Ribble Valley Borough Council  
Housing & Development Control

Application no: **3/2021/0731**

Address: **St James C of E Primary School Greenacre Street Clitheroe BB7 1ED**

The Local Highway Authority have viewed the plans and highway related documents and have the following comments to make:

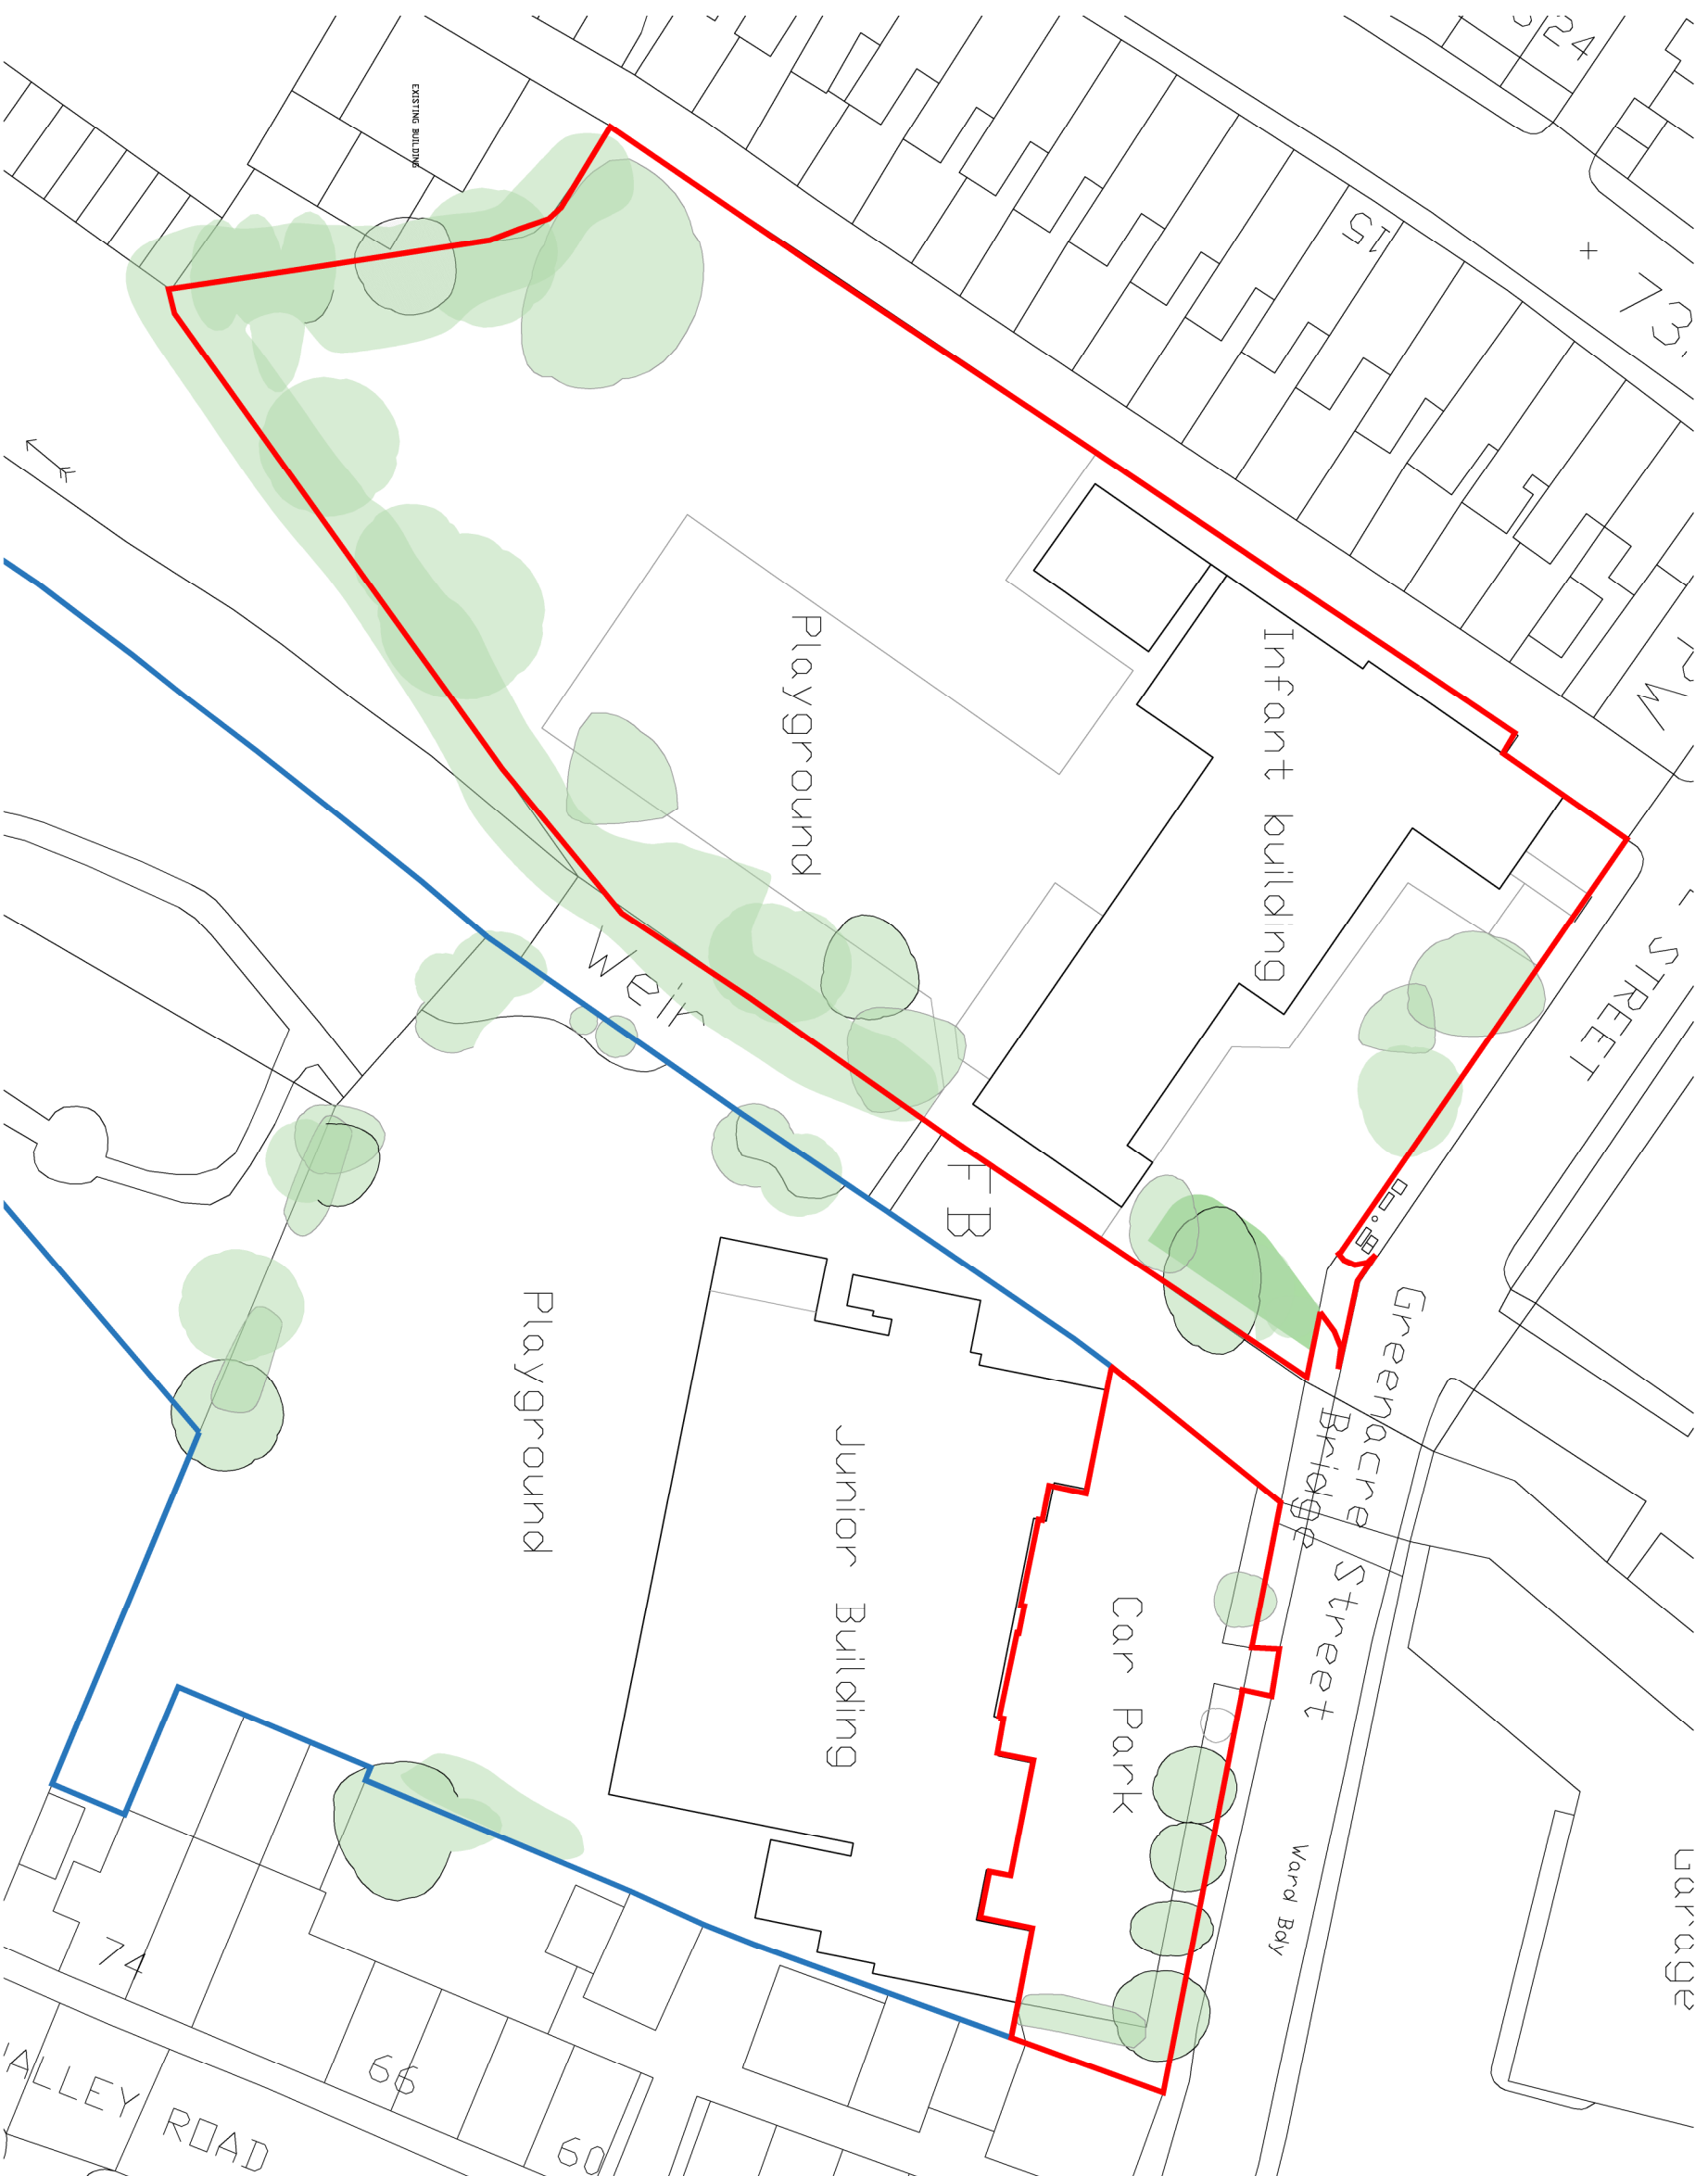
The existing access which will now provide 9 car parking spaces rather than 16 as shown on Cassidy + Ashton drawing number E01 titled "Existing Site Plan," will also be widened from approximately 3.2m to 4.2m as shown on the drawing titled "Proposed Site Plan."
